Application Reference: 2025/0285

Site Address: 64 Strafford Walk, Dodworth, Barnsley, S75 3RB

Introduction: Erection of front extension to existing detached double garage to create annexe.

PROPOSED GROUND
FLOOR PLAN
SCALE 1:50

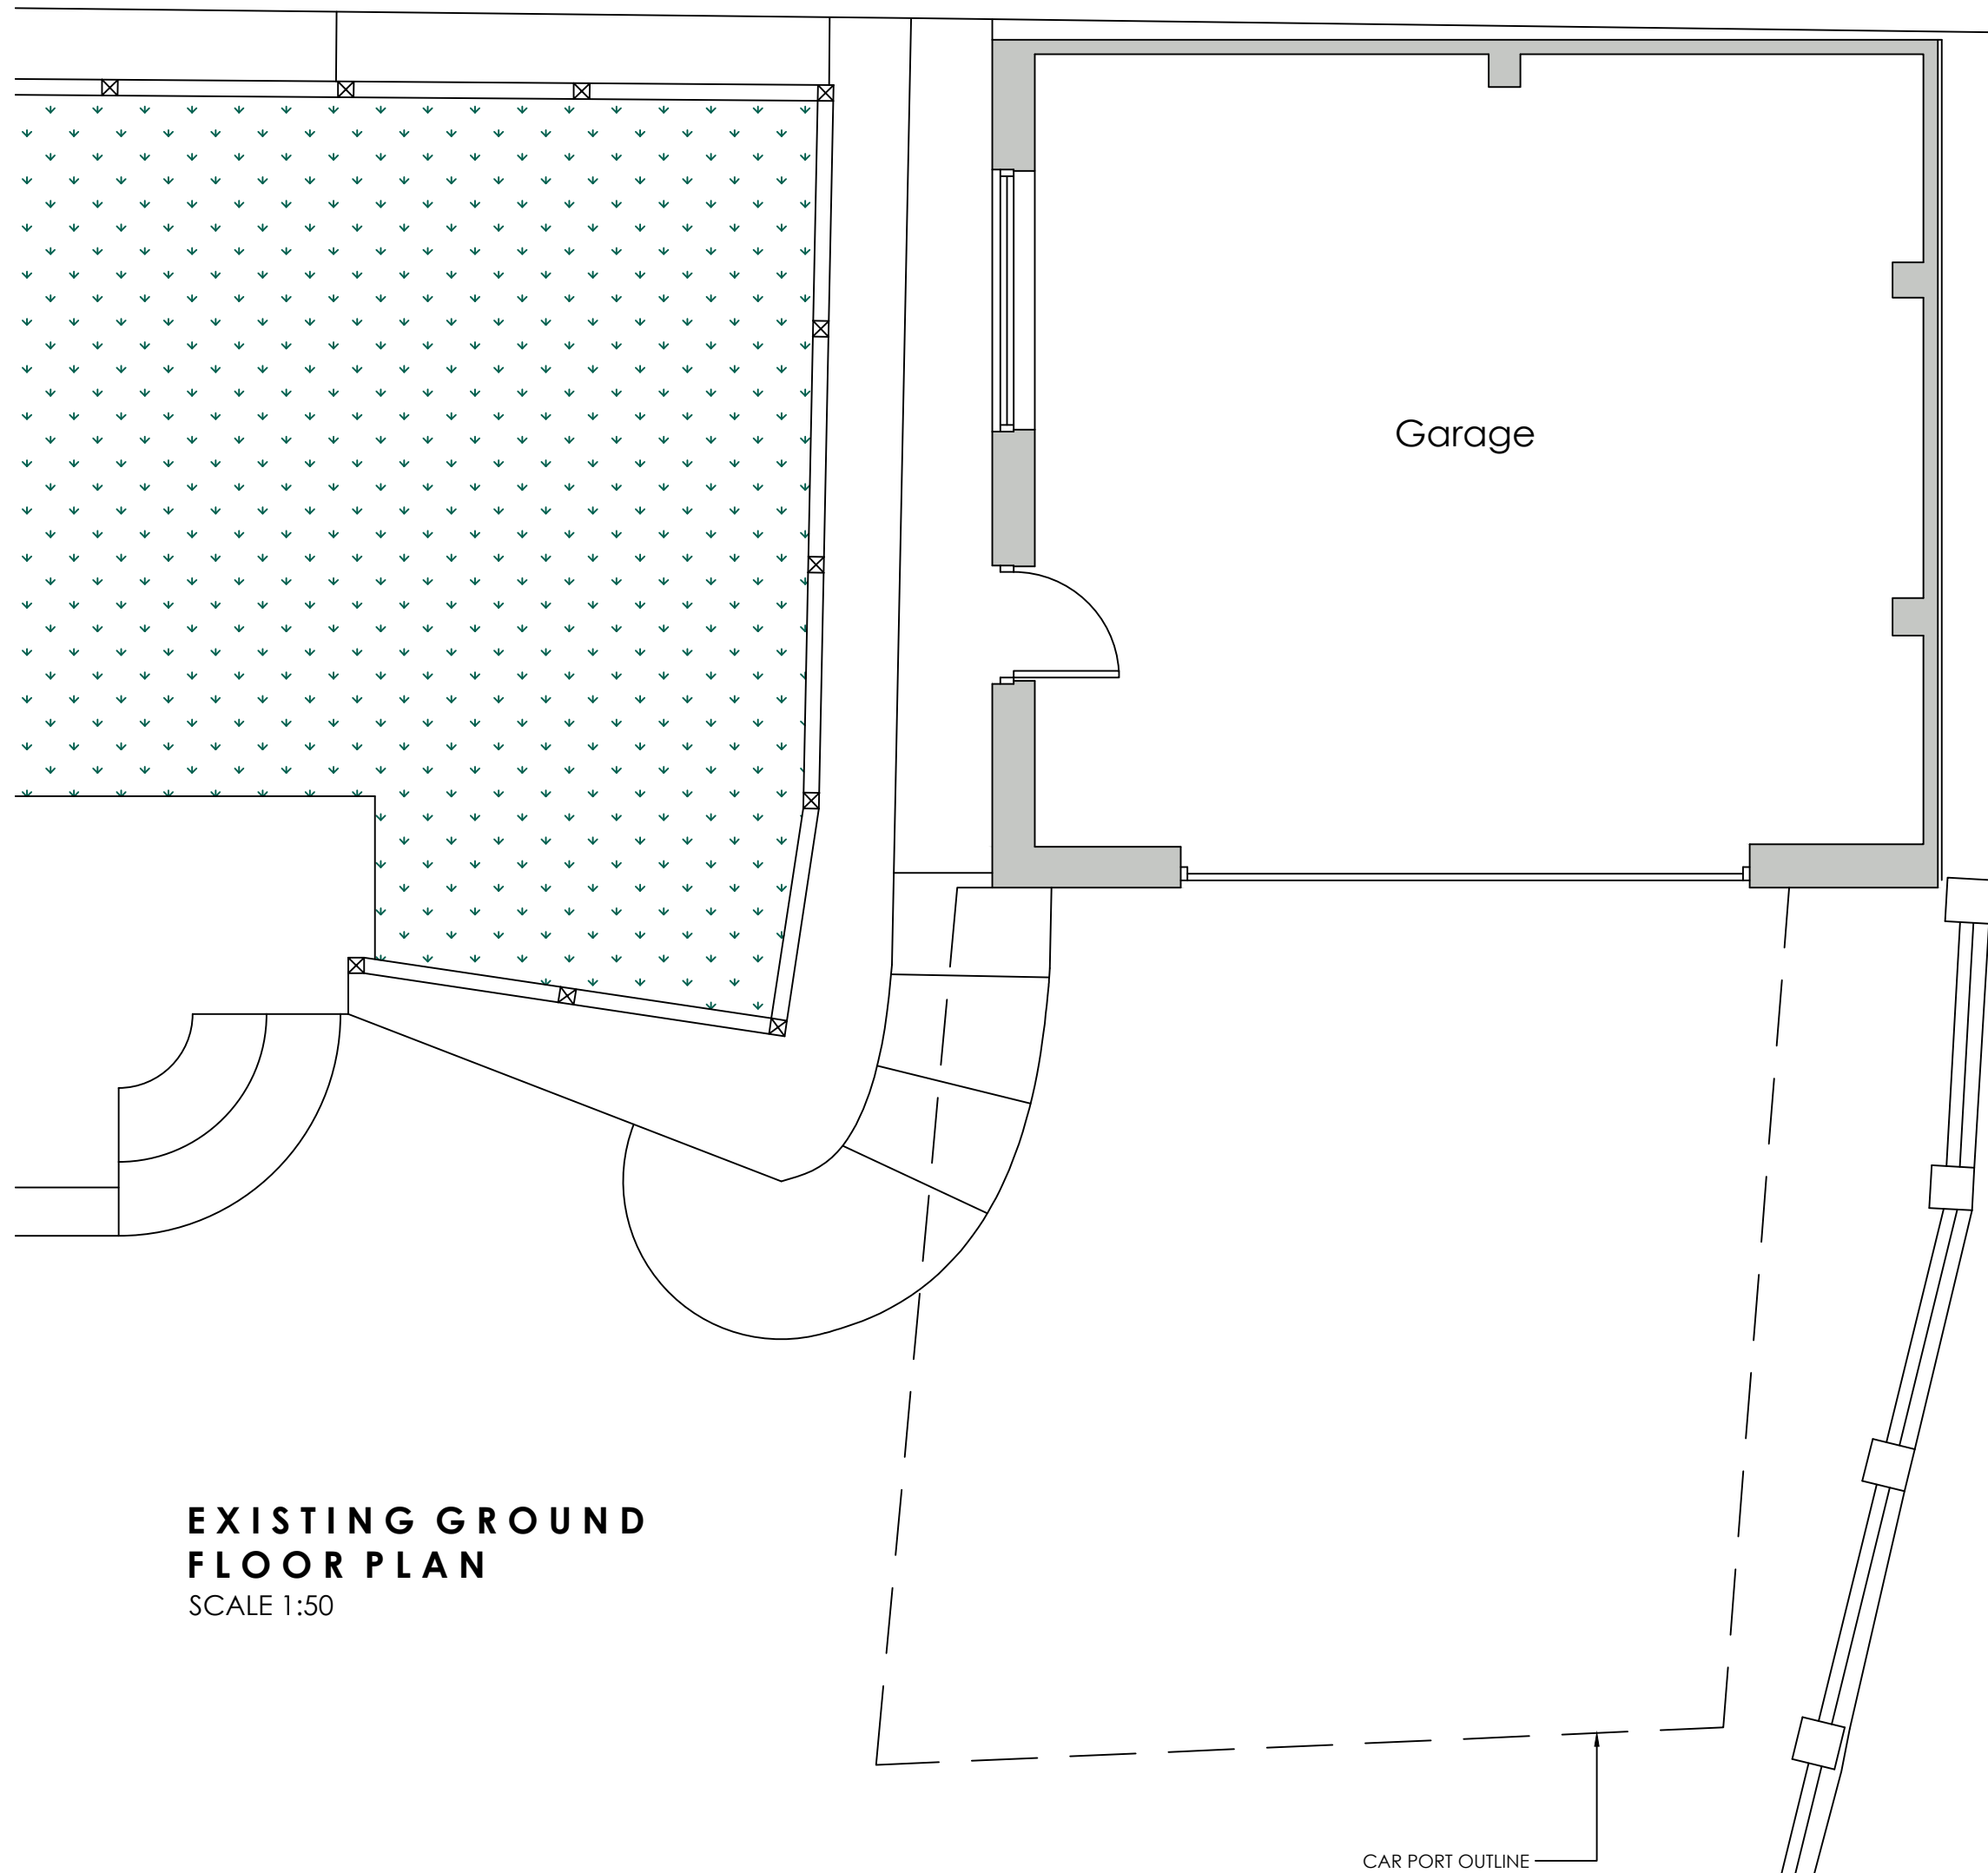
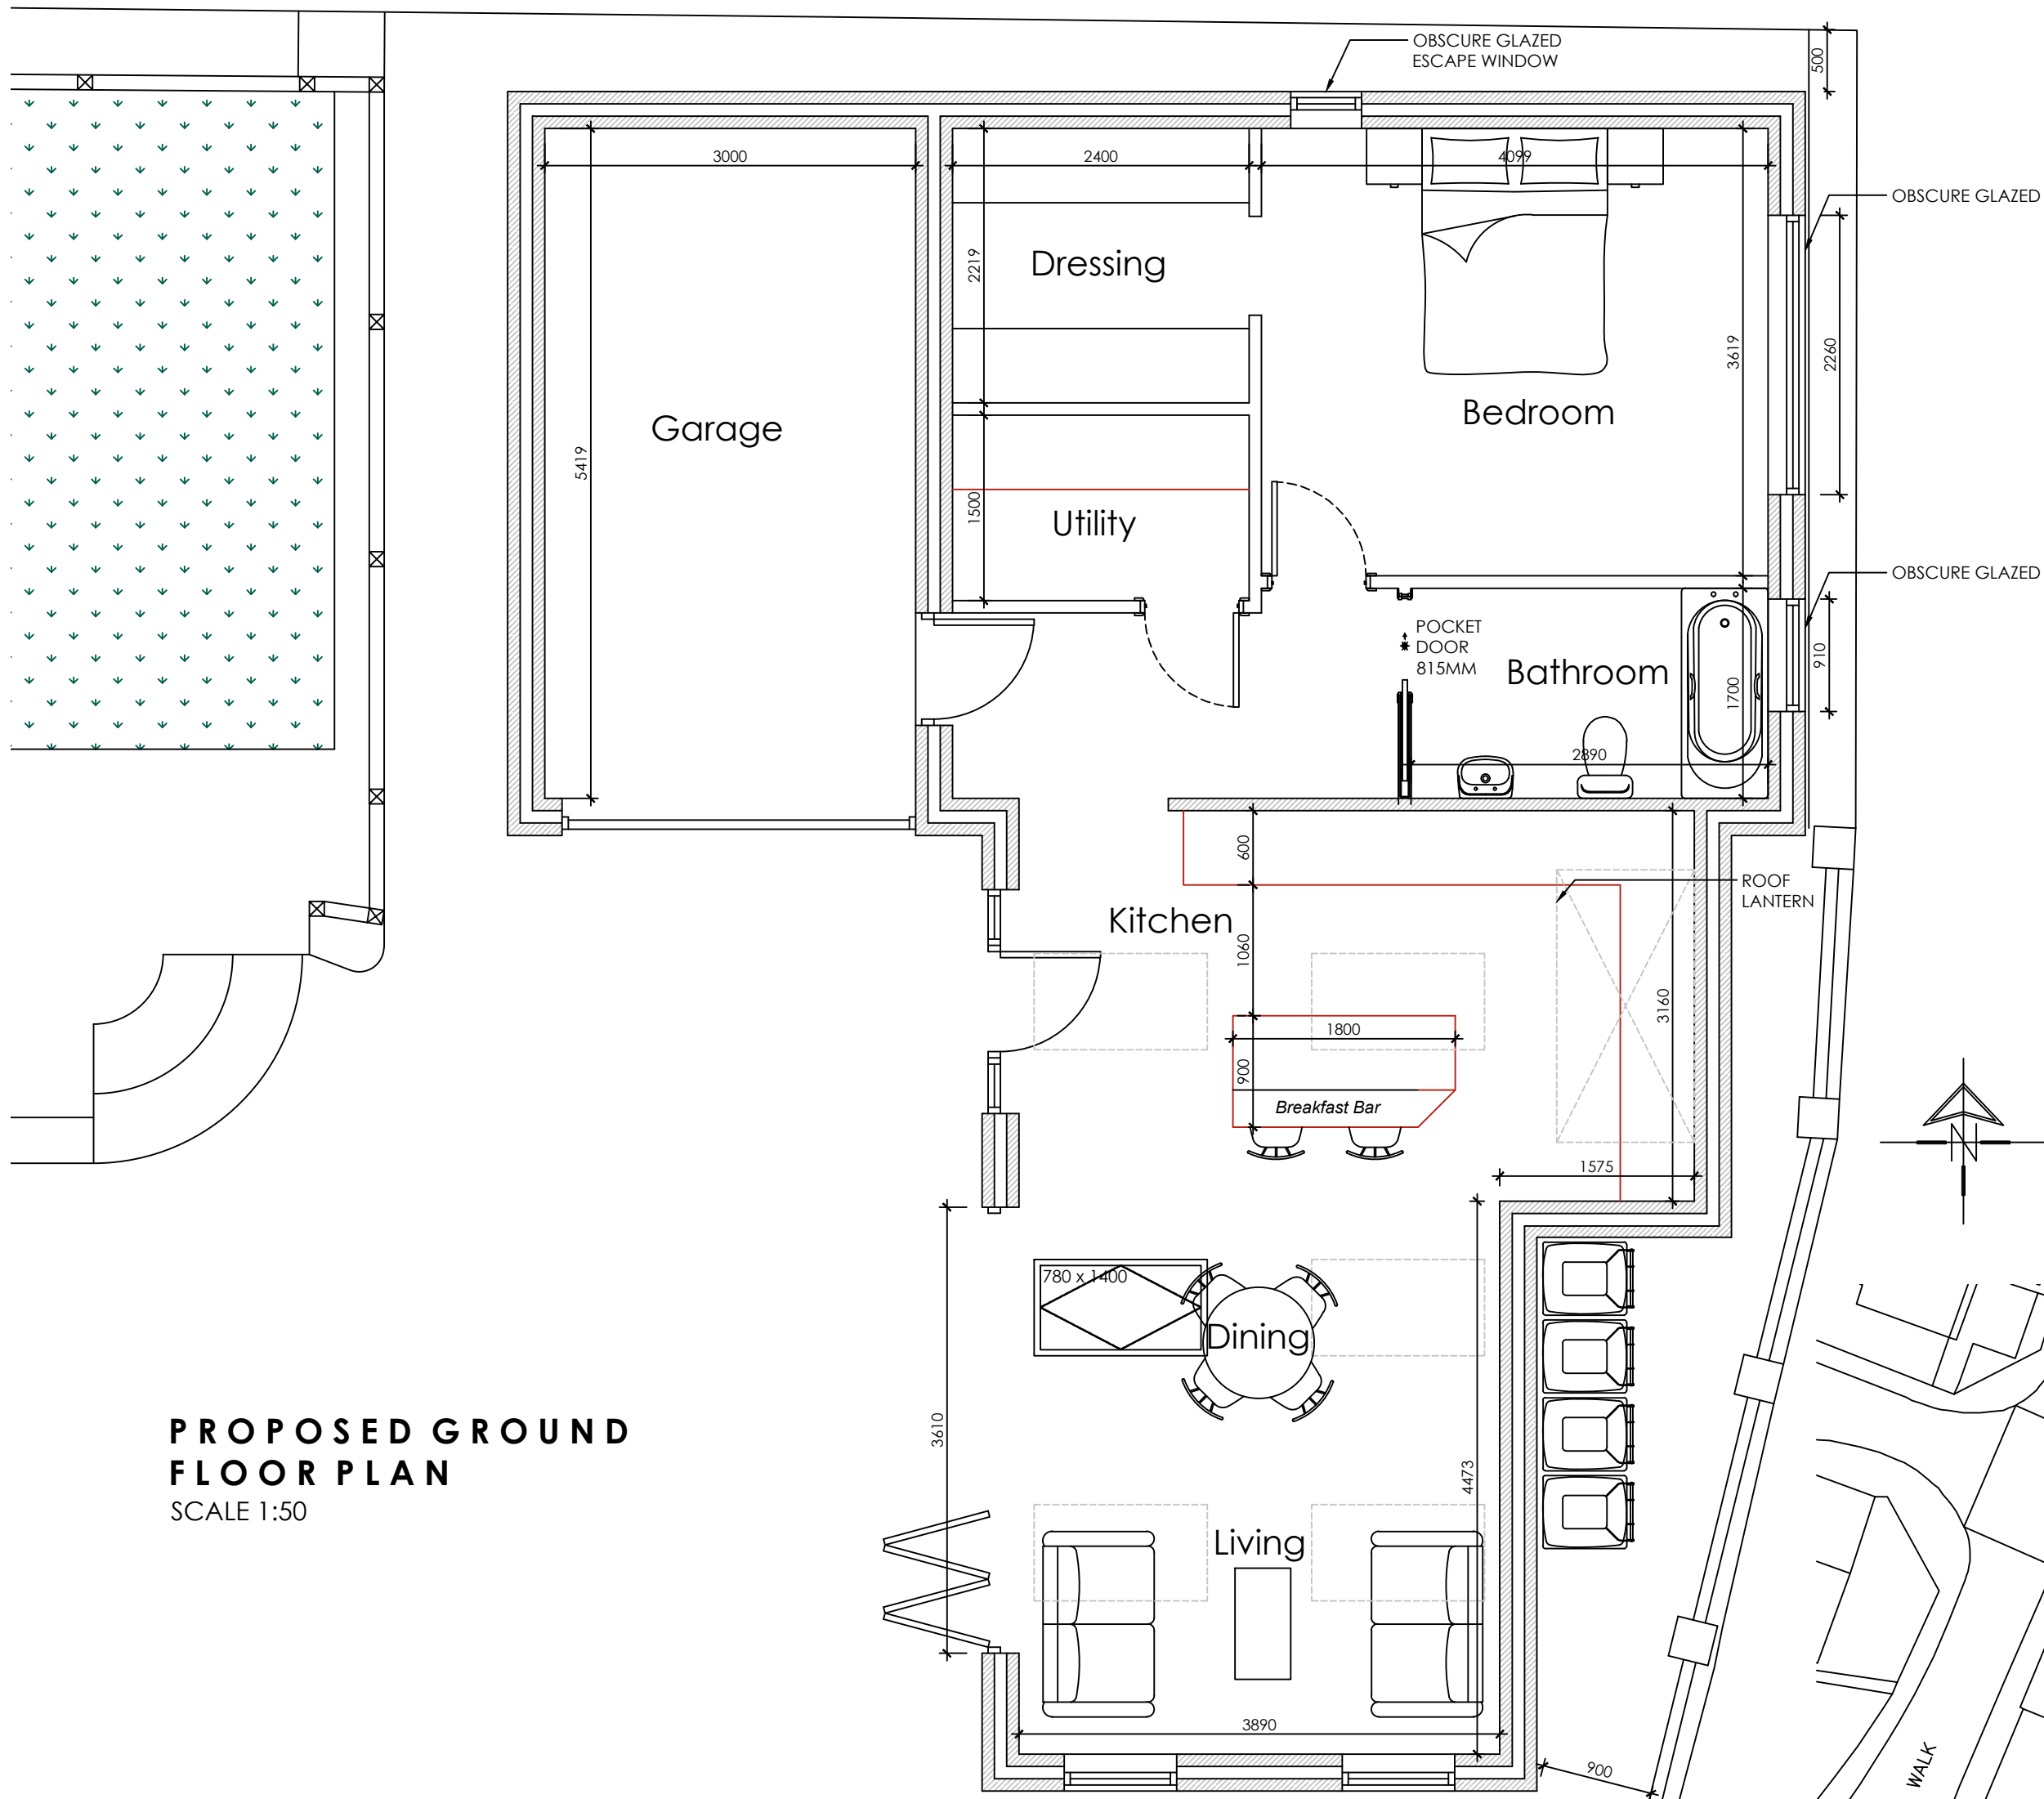
It is outlined within the House Extensions, the size of an annexe 'shall be up to 39m² and no larger than the size of a double garage'. The proposed extension would provide an annexe with a floor space 18 square metres larger than the acceptable size outlined by the house extensions SPD. It is acknowledged the existing garage is slightly larger than 39 square metres at approximately 40.8 square metres. It was suggested to the applicant that converting the garage without extensions would be more appropriate which, although marginally above the House Extensions SPD guidance on this occasion, would allow the existing garage to be converted to an annexe providing a proposal with a floor space of 40.8 square metres. This offer was not adopted. The proposal is therefore substantially larger than what is deemed acceptable by the adopted House Extensions SPD which weighs substantially against the application.

Furthermore, the annexe would not have a close physical relationship with the host dwelling and is without shared facilities. The proposal provides facility for a Bedroom, Dressing Room, Garden Store, Bathroom and combined Kitchen/Sitting room. Irrespective of proposal size, the annexe would not have a reliance upon the host dwelling for any typical residential facilities. The proposed annex could therefore be used as an independent residential unit and therefore would not be compliant with the House Extensions SPD. This also weighs substantially against the application.

A supporting statement from the applicant indicates that the annex is required for elderly parents, and in time, for a son to live in when he has reached adulthood. The proposal provides a floor space of approximately 57 square metres. The South Yorkshire Residential Design Guide advises a 1 bed, 2 person dwelling should provide a floor area of 47 square metres and a 2 bed, 3 person dwelling should provide a floor area of 62 square metres. The proposed annexe would therefore provide a floor area which exceeds the requirements for a 1 bed, 2 person dwelling and is instead of a size tantamount to a new 2 bedroom dwelling on the site.

It has been necessary to make contact with the applicant to request plans and elevation which provide a reduced floorspace in line with the 39 square metres outlined as acceptable within the House Extensions SPD. Given the current garage exceeds this size at 40.8 square metres, a compromise was offered to convert the existing garage into an annexe providing a floorspace exceeding the 39 square metres outlined within the House Extensions SPD but matching the existing 40.8 square metres floorspace of the garage. A site layout plan was also requested to demonstrate the site can accommodate the parking and turning of vehicles.

The proposed block plan provides acceptable manoeuvrability within the site. The creation of a designated parking space has been provided to the north of the annexe. The site provides a substantially large driveway providing ample space for further onsite parking to accommodate the existing dwelling and the proposed annexe.
